WEST SUSSEX COUNTY COUNCIL CONSULTATION

TO:	Arun District Council FAO: Jessica Riches
FROM:	WSSC – Highways Authority
DATE:	8 January 2026
LOCATION:	Church Barton House Horns Lane Bognor Regis PO21 4NZ
SUBJECT:	P/173/25/DOC Approval of details reserved by condition imposed under P/25/17/OUT relating to conditions 4-detailed phasing for dwellings, highways and public areas, 5-schedule of materials and finishes, 20-Employment and Skills Plan and 22-energy conservation.
DATE OF SITE VISIT:	n/a (desktop study undertaken – site visited at outline stage)
RECOMMENDATION:	Advice

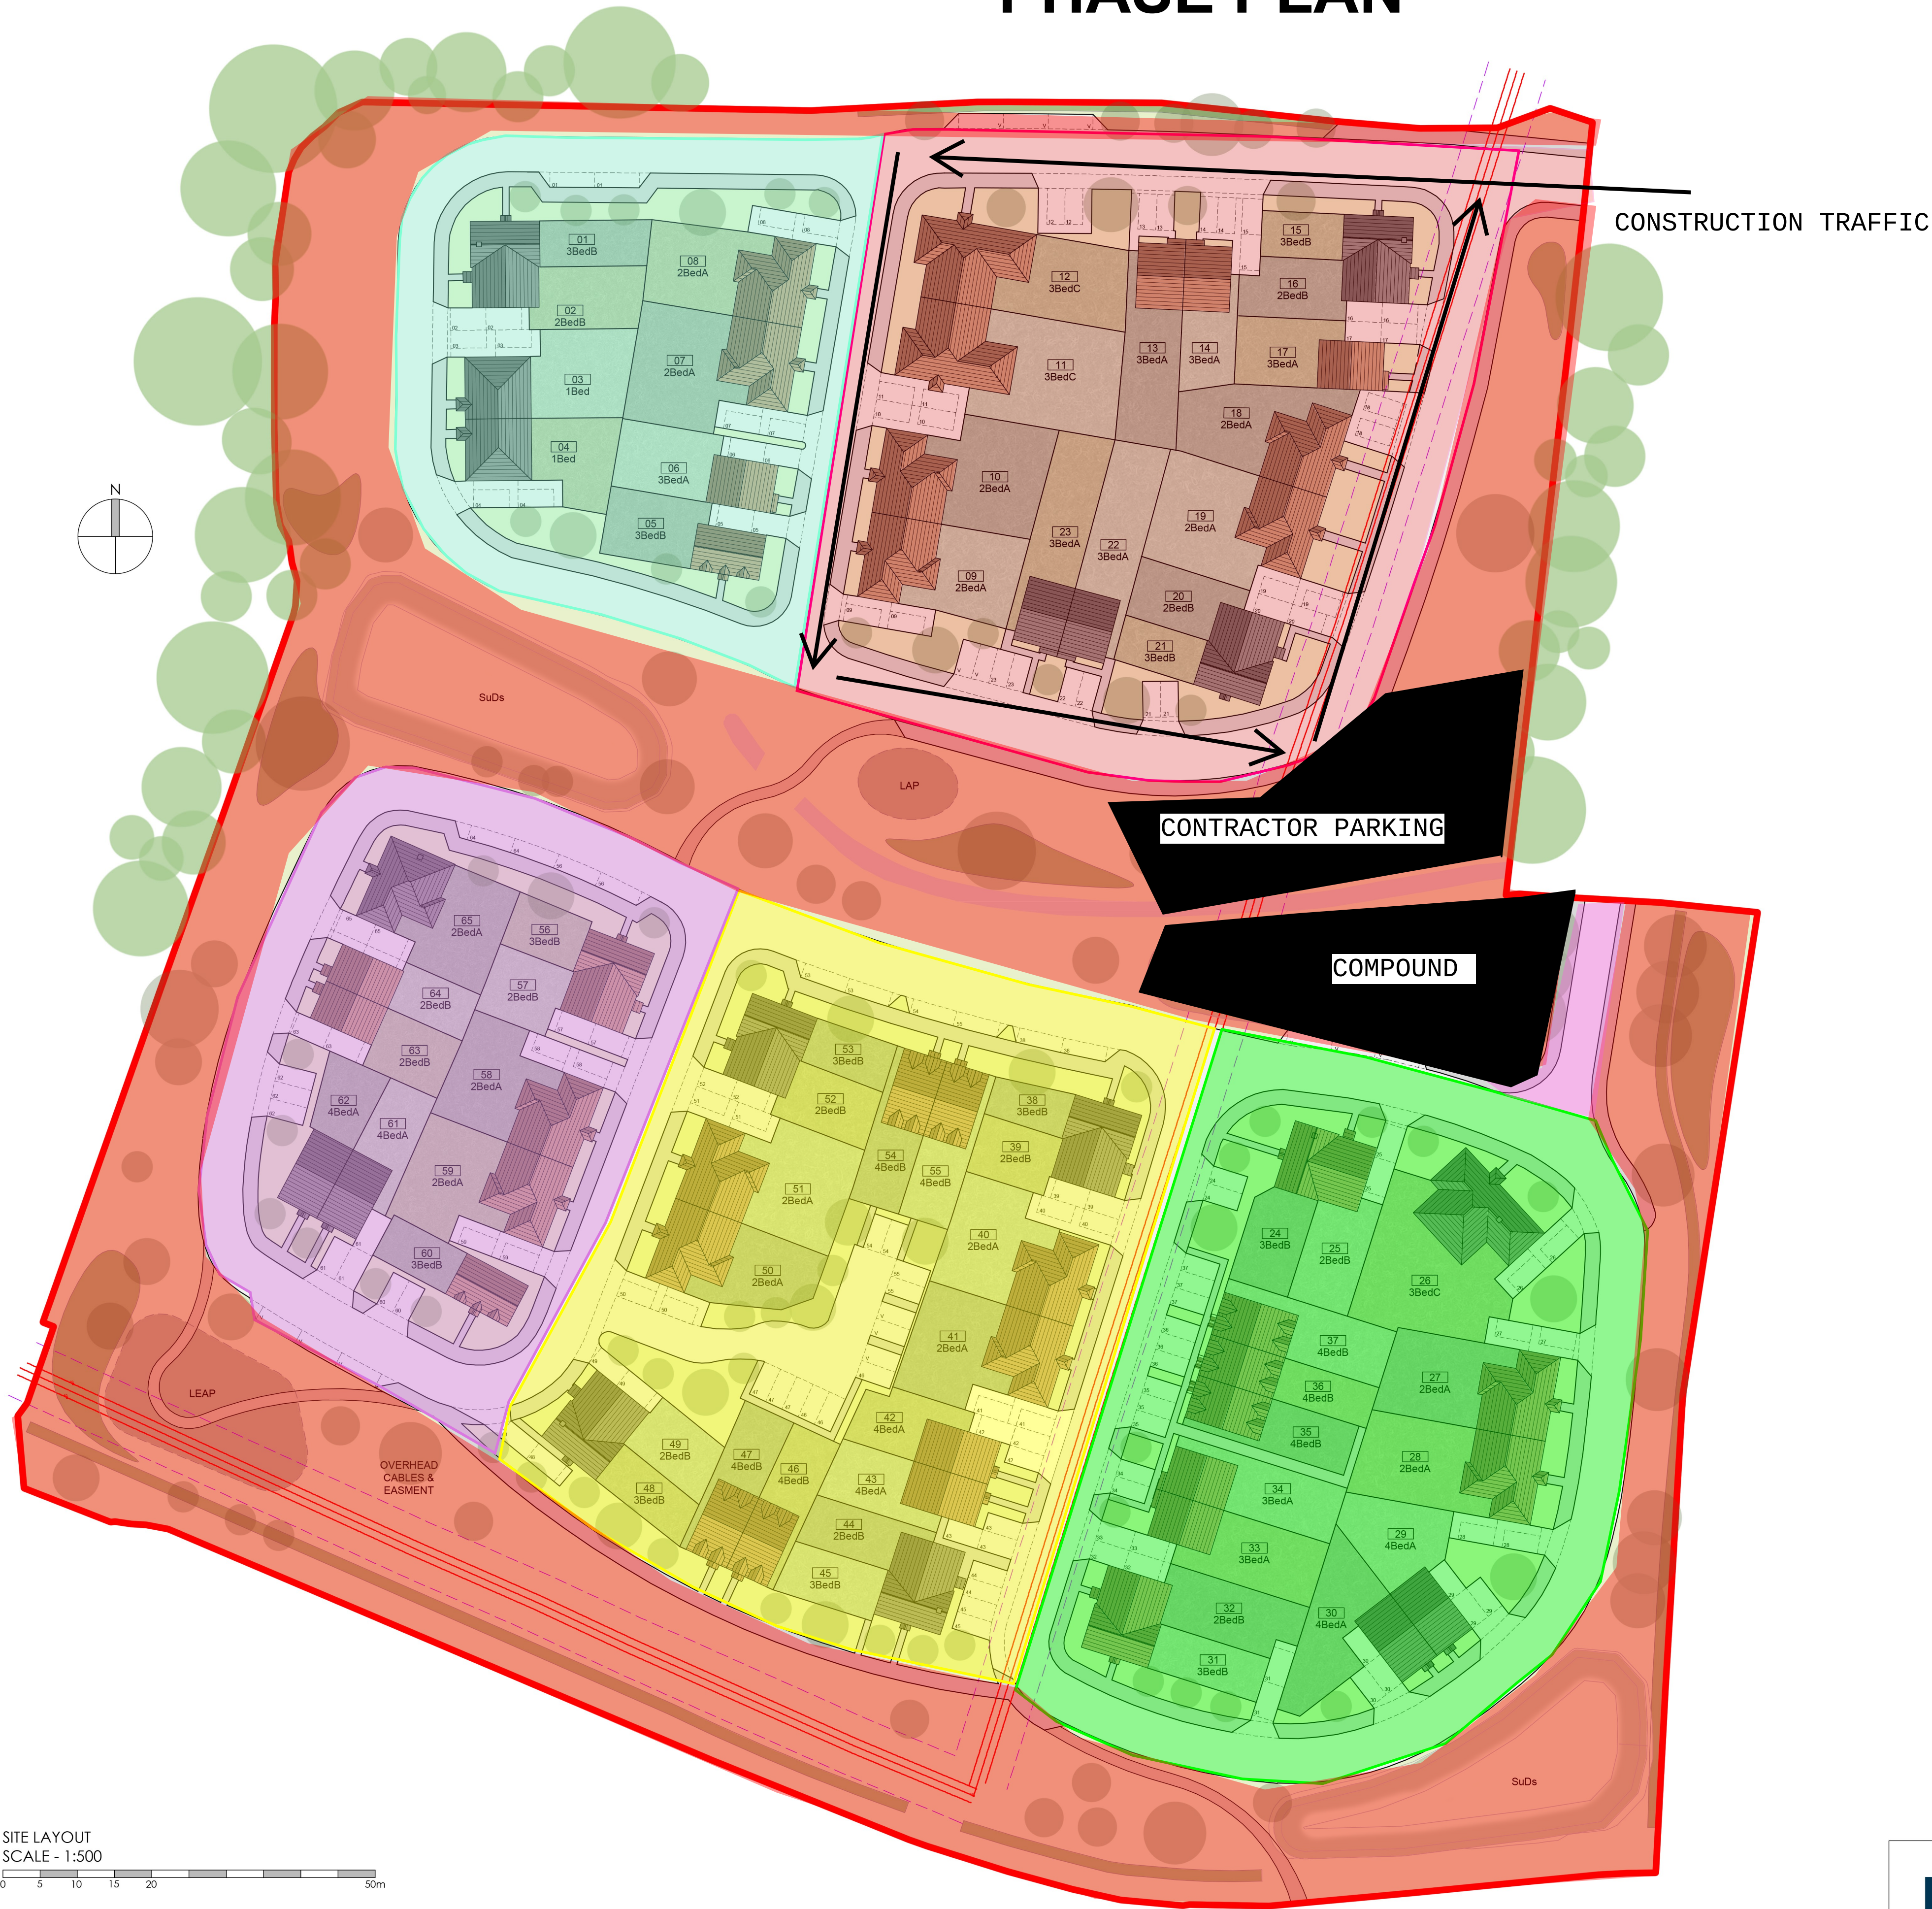
Having reviewed Drawing No. 22039-P-2-02 Revision 'A' (the highways/construction phasing plan), this appears to show highways access being taken from the development due to be constructed to the east. All access to the site shall only be via the development to be constructed to the east. There shall be no access from Summer Lane or the track/lane leading off Summer Lane into the site.
